DRAINAGE AND TRANSPORTATION INFORMATION SHEET
(Rev. 12/05)

PROJECT TITLE: Broadstone Santa Monica ZONE MAP/DRG. FILE# D-18-71054
DRB#: _____ EPC#: _____ WORK ORDER#: _____

Re: Broadstone Santa Monica—D18/D054

**Re: Broadstone Santa Monica Place
Grading and Drainage Plan
Engineer's Stamp dated 3-7-2012 (D18/D054)**

OVERFLOW WEIR AT CONCRETE STILLING BASIN @ NW CORNER

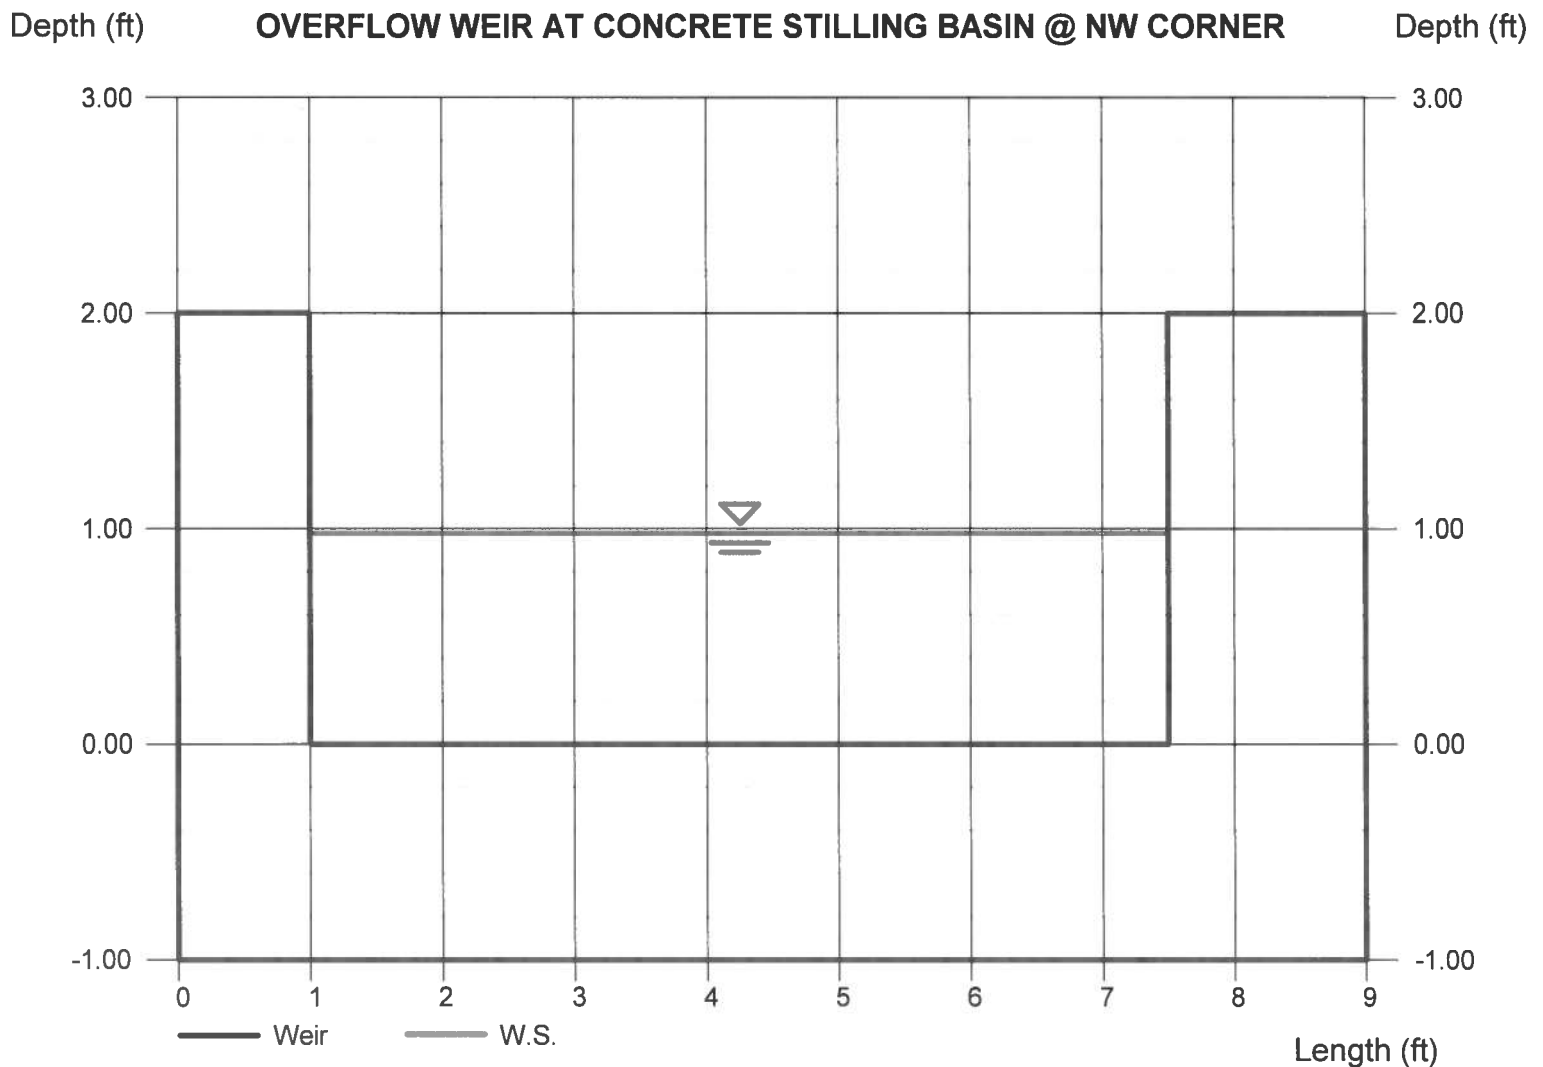
- Pond calculations are needed for the small pond just north of the entrance/exit on San Pedro. What is the WSE?
- How are the proposed contours tying in with the contours to the north of this site at the NW corner?
- Provide the direction of roof flows for the units in the NW corner. These flows should not drain over the sidewalk.
- Are all landscape areas being depressed as well as the areas with sidewalk culverts? Can the small islands in the parking lots contain a 1' cut in the curb to accept flows? This would assist in lowering the flows entering San Pedro for the first 6 hours and would also help with the new EPA regulations and the MS 4 permit coming in the near future.

1. The intent of the storm drain outfall structure is to dissipate the velocity of the storm drain discharge and overflow it to the south paved drive over a 6.5-foot wide weir. Flow remaining in the lower 6 inches will pass to the north via the proposed 4-inch drainline. The peak flow in the 4-inch pipe is 0.5 cfs and the remaining flows of 21.0 cfs discharges via the weir. See Supplemental Calculations for weir overflow and 4-inch orifice calculations. Based on these calculations, the water surface elevation will be 63.0—one foot above the flowline elevation. The curb adjacent to the weir will be 12 inches high with transitions to the top of wall elevation of 64.5.
